Submission No.			11	
Organization Name or Name of Submitter			Anne Behan and John Kearns (79 Seatown Villas, Swords, Co Dublin)	
Item No.	Section Ref.	Page No.	Observation Statement	TII Response
Letter Re: Railway Order Application - MetroLink: Estuary through Swords, Dublin Airport, Ballymun, Glasnevin and City Centre to Charlemont, Co. Dublin				
1	Section 1: The plan for new openings/access into Seatown Villas from the Linear Park proposal	1	We fully support and agree with the other Seatown Villas residents who had a chance to speak on the call back in October 2021 and outlined their objections to opening up an access point between the R132 and Seatown Villas via the proposed linear park (refer to image 1 & 2). There is no good reason to do this. All it will do is drive additional traffic both vehicular and pedestrian (walking/cycling) into a very quiet residential area.	While noting your comment supporting an objection to a linear park along the route of the Metrolink, its purpose is aligned to the Fingal Development Plan 2017-2023 (Draft Development Plan 2023-2029) and with Fingal County Council R132 Connectivity Project recently consented. Further detail supporting this state

Project	Drawing Title	Drawing Status
Estuary - Seatown Landscape Layout Preliminary Design Issue		S4
Drawing N°	ML1-JAI-ARL-SC01_XX-DR-Y-00001	
Scales Original Size A1	1:1000	Sheet 1 of 3

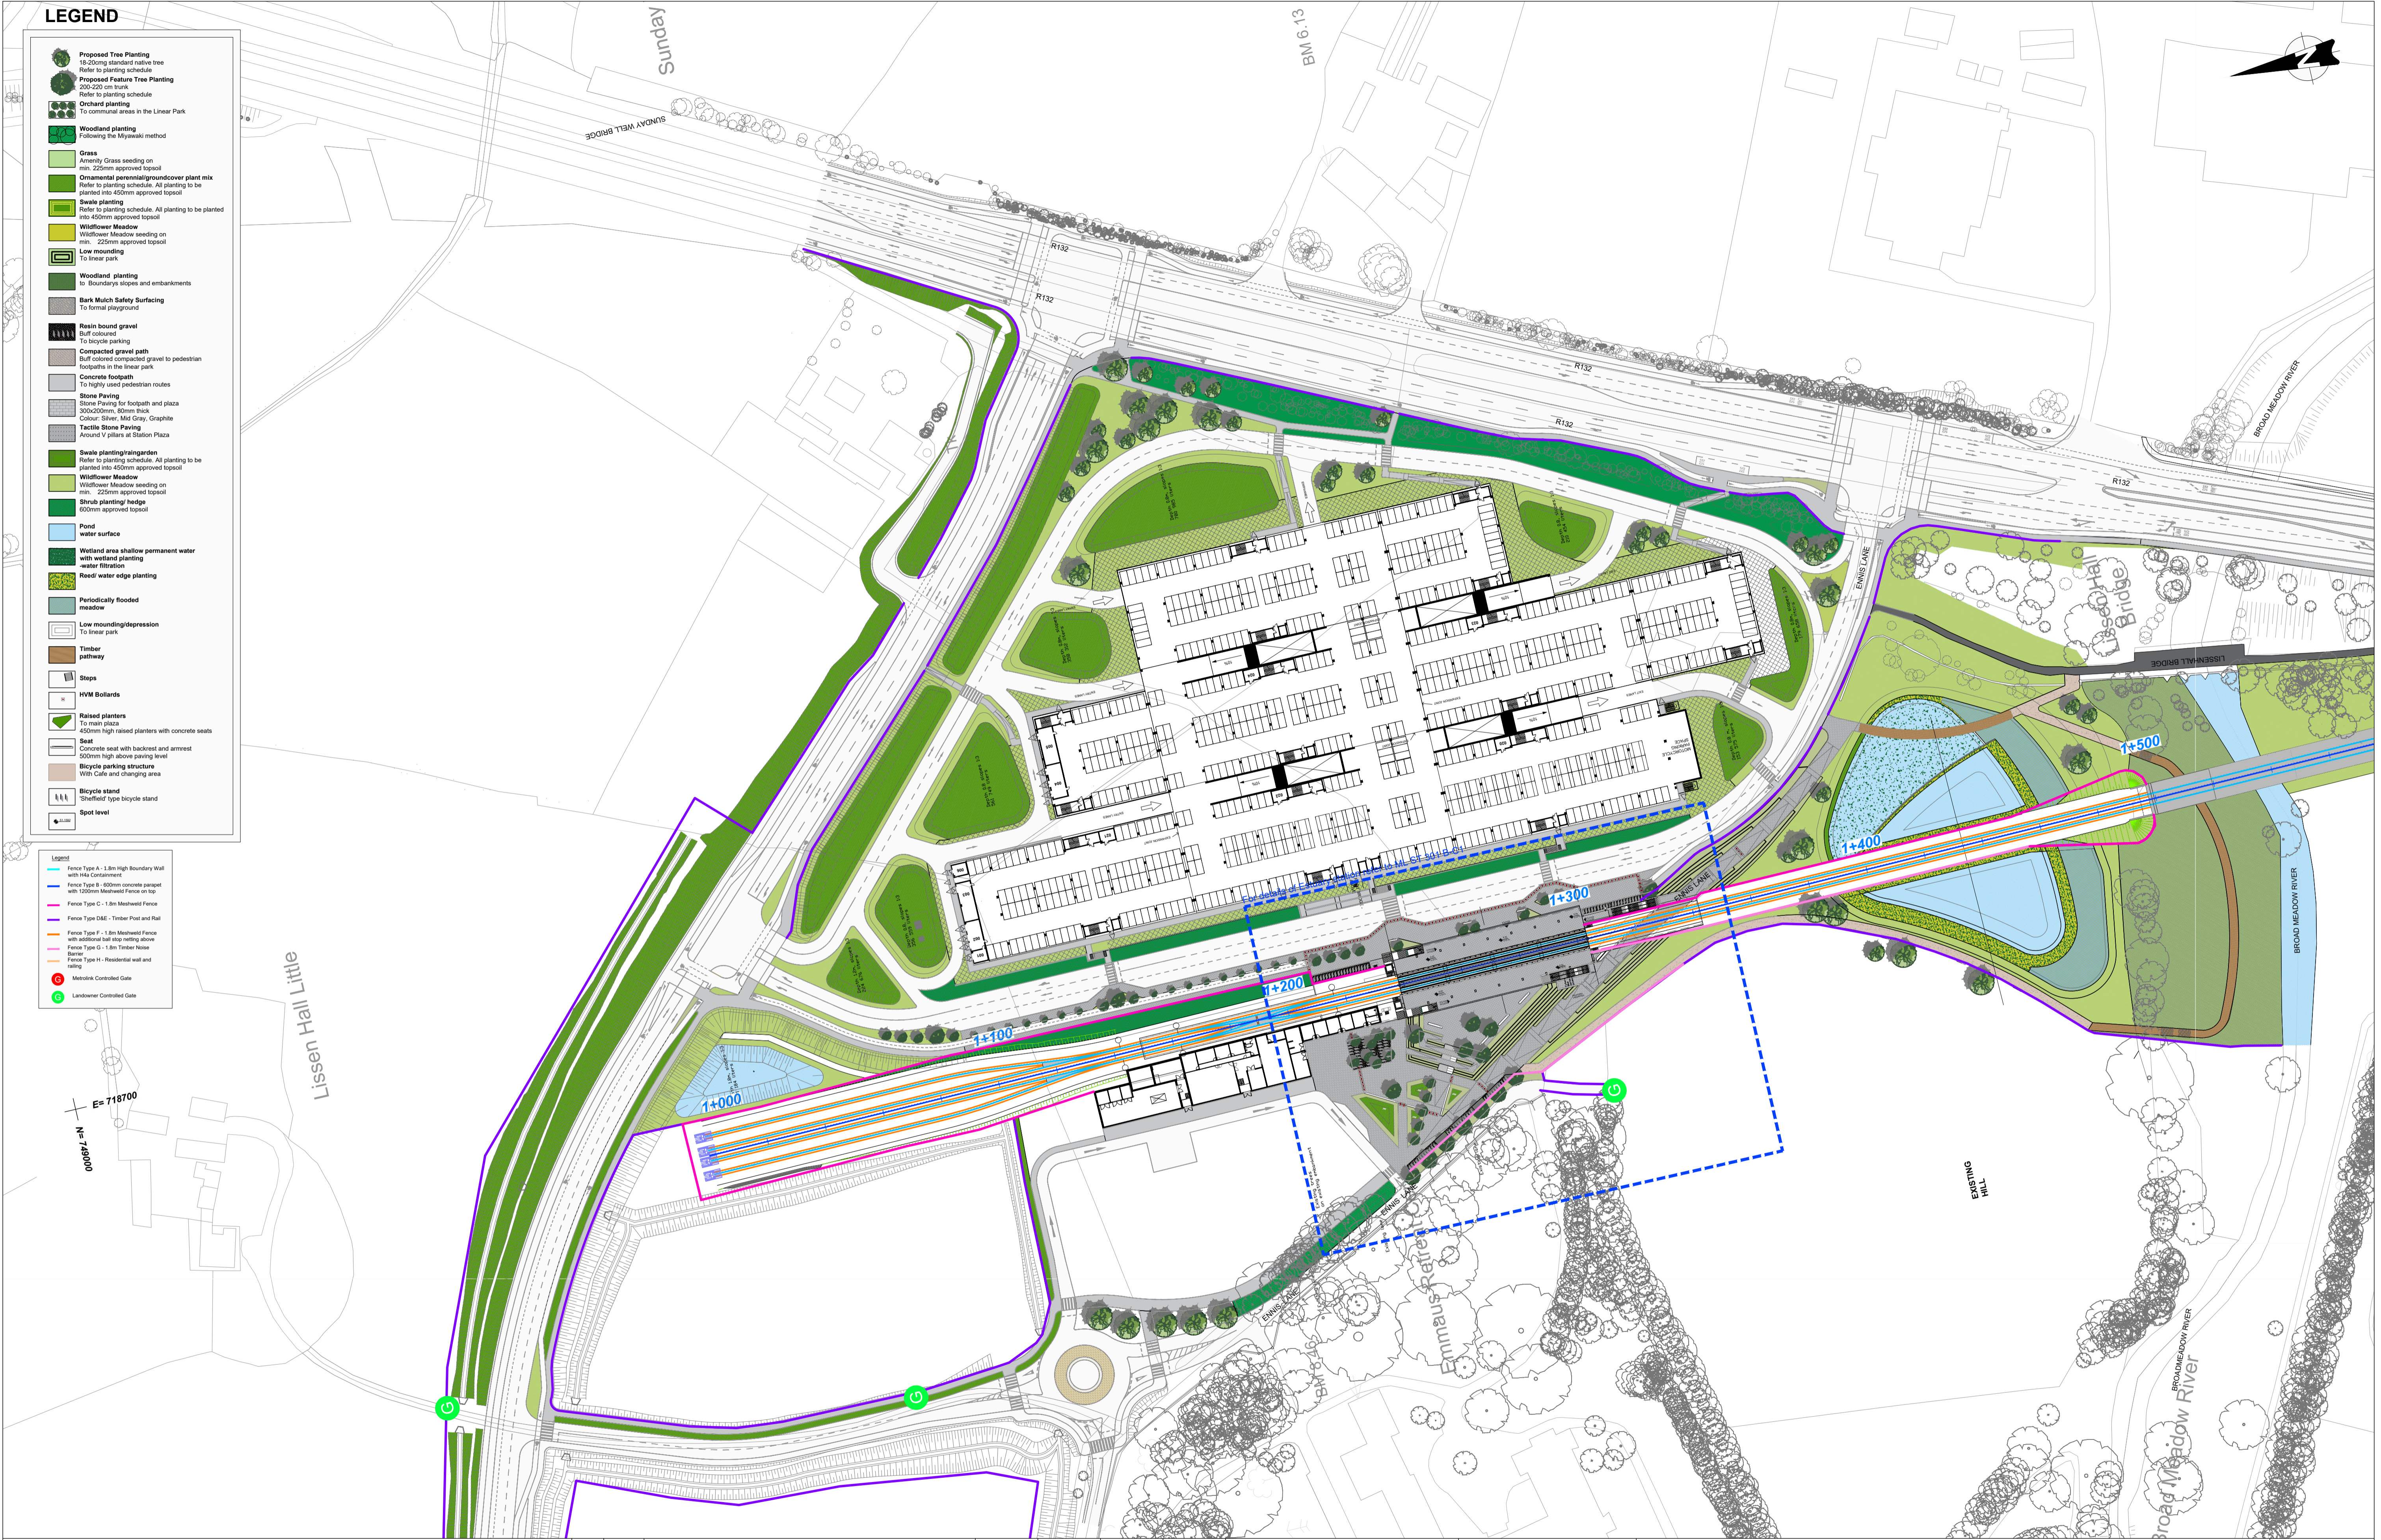
5	Section 1: The plan for new openings/access into Seatown Villas from the Linear Park proposal	3	At the other end, it (the proposed linear park) only serves as a shortcut between Estuary Court and North street via Seatown Villas. Something that is not required as there is direct access from Estuary court via the pedestrian bridge over the Seatown roundabout on the R132 and will continue in the new proposed R132 Connectivity project where the proposed Seatown Road junction concept has both pedestrian and cycling crossings provided at all sides of the junction for easy crossing to either side of Seatown road or south along the R132 which would be the intended direction of travel for the majority of crossings at this junction to access the new proposed Seatown Metrolink station.	See response numbers (1) and (2) and (3) in relation to the landscaping proposals for this area.
6	Section 2: Alignment of the rail line and the construction method	5	We would also like to raise a question on the planned construction method described for the portion of the line that will be coming through Seatown Villas in the proposal. There is a section of the line once it is inside the current Seatown Villas boundary described as retained cut design (refer to image 5). Why is this being included in a residential area? Why can't this portion of the line continue as Cut and Cover design, the same as the portion of the line that enters and exits the current Seatown Villas boundary? At least, then there is a possibility to return the green space to closer to what it is currently after the construction works are complete. We would like more information on this regarding studies, regulations and requirements that would dictate for a retained cut section in an otherwise short section of tunnelled track.	A retained cut as opposed to a cut and cover solution has been proposed in this residential area as it is required to ensure the section of cut and cover south of this point will be adequately ventilated. Removing the retained cut section and replaceing it with a cut and cover solution will lengthen the cut and cover section requiring the provsion of active ventilation fan systems and may compromise emergency egress and evacuation arrangement in the event of an emergency. See also response number (10) in relation to the construction methodology.

8	Closing paragraph	6	There is no good reason why the current space and boundary conditions could not be returned when the works are complete.	See response numbers (3) and (7)
9	Closing paragraph	6	The green space and mature trees in Seatown Villas should be treasured. It is not progress to destroy them.	See response numbers (3) and (7)
10	Closing paragraph	6	These cut and cover & cut and open methods of construction are just cheaper alternatives to full tunnel construction which is what we have been promised since the first “Metro North” project back in 2001.	<p>TII have not arrived at the proposed solution for MetroLink through Swords without careful considerations of all of the options available. The final route selection now proposed has evolved from a Route Alignment Options Study, that commenced in 2016 that considered four potential route alignments through the Swords area.</p> <p>One of those route options in this study was along Swords Main Street in tunnel and this was included in the New Metro North Alignment Options Report as part of the preparation for the Emerging Preferred Route (EPR) Consultation process.</p> <p>However, it was not considered to have the same potential to support regional and local growth objectives for Swords and its environs when compared with an alignment along the R132 and therefore was not selected for the Emerging Preferred Route and consultation in 2018.</p> <p>A tunnel is usually the last option considered once other viable alternatives have been ruled out and is thus more typically appropriate in built up city areas due to the excessive demolition of buildings that would be required by other solutions.</p> <p>The EIAR Chapter 7, Consideration of Alternatives details the options that were looked at. [See section 7.6.4.3.3 for option assessment at the northern end of the line]</p>
